# PORTLAND MAINE

February 20, 2013

RE: 87-K-2, 87-K-8, & 87-K-29 Island Avenue & Pleasant Avenue, Peaks Island –  
IR-2 Zone

BOUNDARY SURVEY OF LAND
48 PLEASANT AVENUE AND 308 ISLAND AVENUE
PEAKS ISLAND, PORTLAND, MAINE

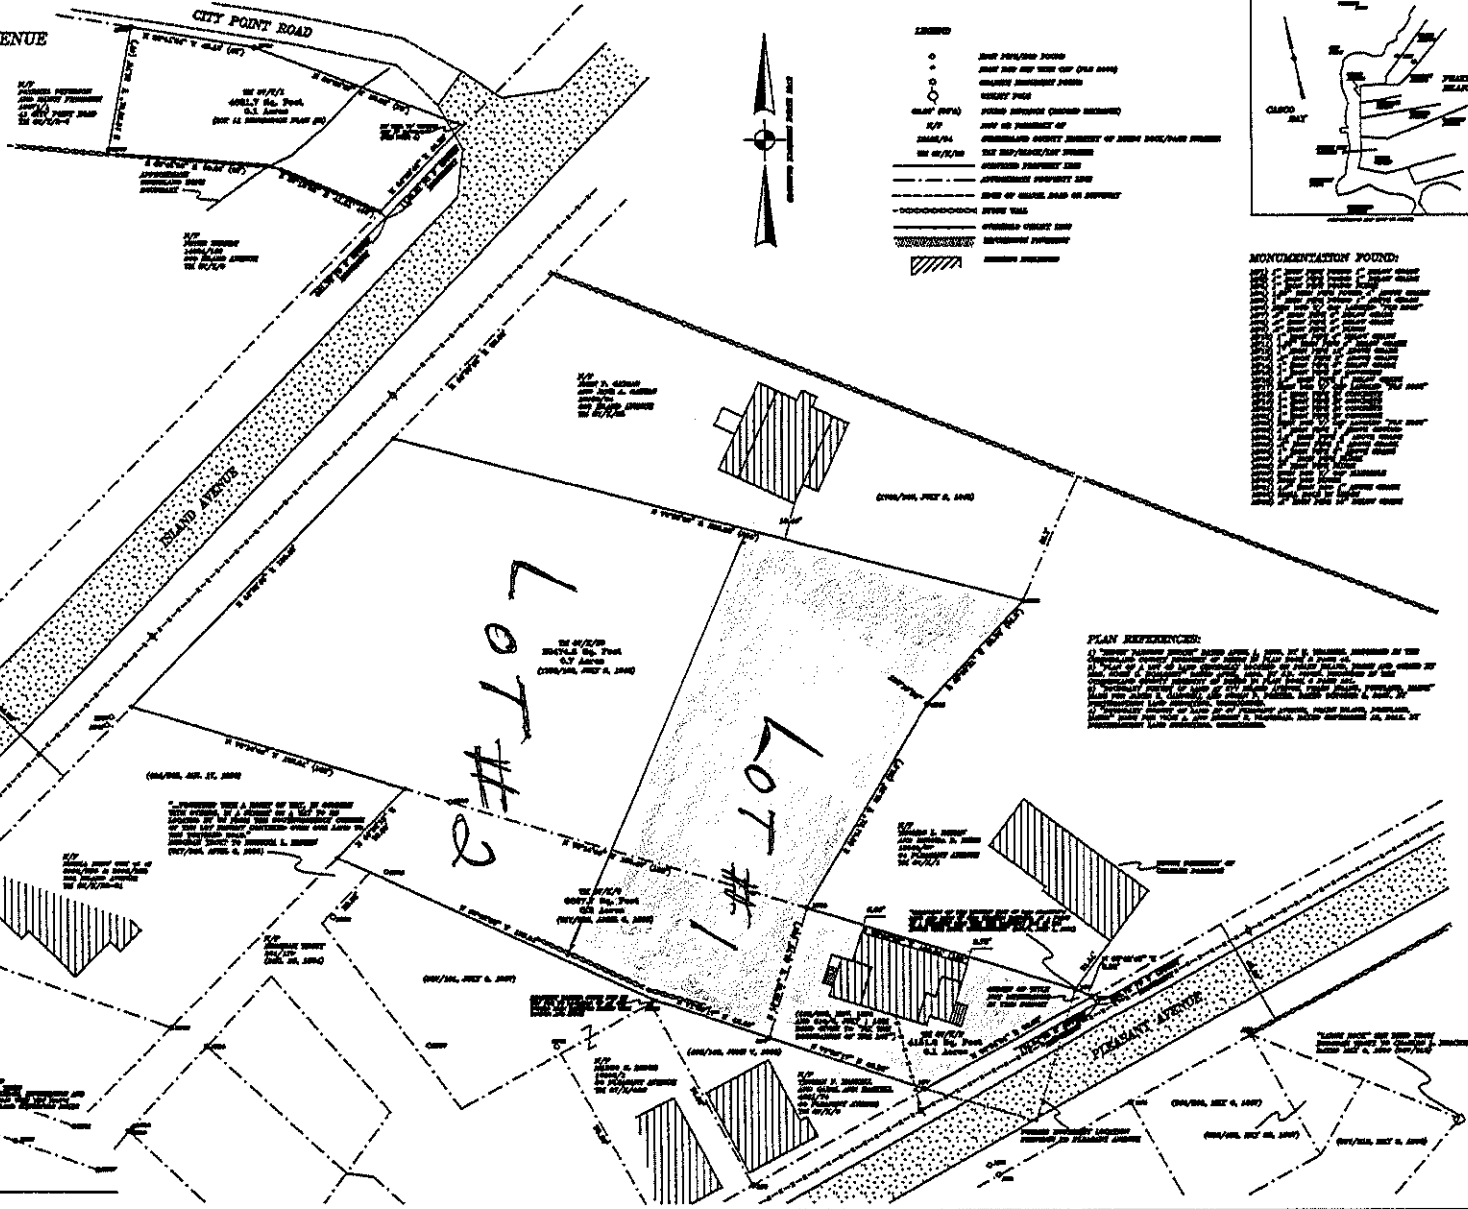
I have been given two reduced copies of the survey each suggesting a different division of land into two parcels. Based upon the IR-2 zoning requirements, option "A" would not meet the underlying zone requirements requiring 70 foot of street frontage [section 14-145.11(b)]. Please note that section 14-422 does not permit the division of land if any lot shall be so reduced that yards, lot width, *lot frontage*, lot area, area per dwelling unit, and space for off-street parking and/or off-street loading shall be less than the minimum required under the Land Use Zoning Ordinance. Currently the one lot is meeting the minimum street frontage requirements using both Pleasant Avenue and Island Avenue as combined street frontage. It is agreed that either division of land options will not affect the current legal nonconformity of the existing single family dwelling for the northern side setback, for the minimum lot width, or for the minimum front setback.

Therefore, at this time before a formal division of land is completed with a survey, the concept of option "B" appears to better meet the Land Use Zoning Ordinance and based upon the information given in your letter, would meet the requirements of the IR-2 zone.
